Subject: RE: 22 Beach Road, Littlehampton.

Thank you for your report, Issue 1, dated 20th September 2019 in respect of Project Number J2707, (as attached), which was amended in the light of my previous comments and my E Mail 4th September 2019, as below.

I can confirm that I agree the contents of this report and have no objection to discharge of the relevant Condition 4 (LU/321/17/PL) on this basis. Given that this report also examines the effect of flue noise on these flats which was found to be acceptable, then I also agree to discharge of Condition 3 in respect of LU/56/17/PL.

Figure 7. Review of 1-hour periods inside Flat 1 bedroom

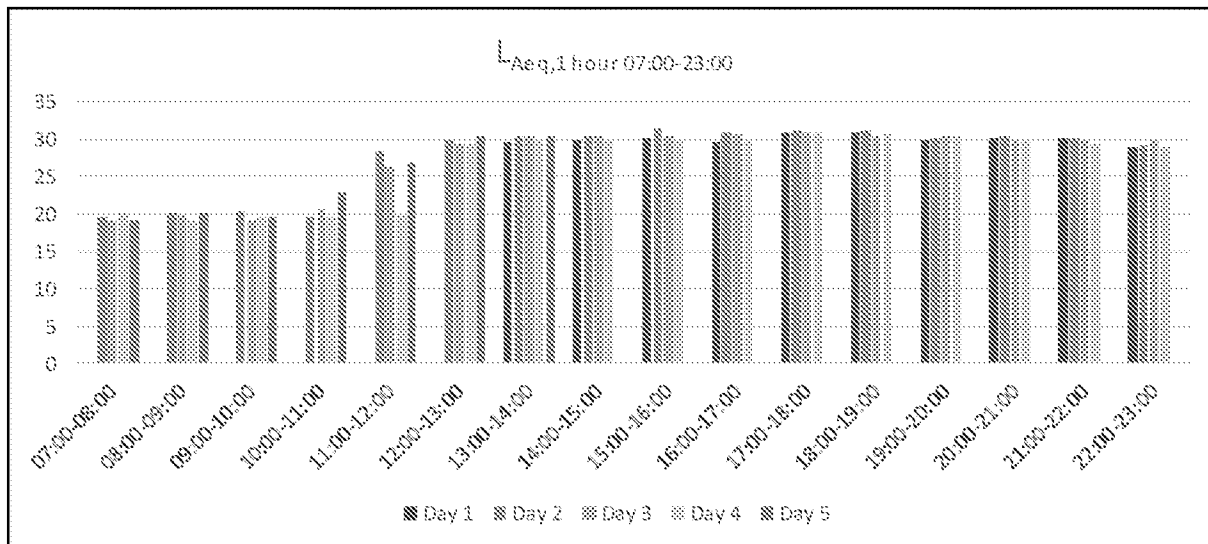
In respect of your report, 23rd August, page 3, paragraph 3 then to clarify, my comment related to Figs 6 & 7 and Flat 1 where daytime noise was found to be 28.8 with windows closed and therefore 39 to 44dB with reasonable adjustment for an open window.

Figures 6 and 7 in the report relate to Flat 1, however the references to 39 and 44dB relate to Flat 2, front bedroom, which is reported in Figure 10.
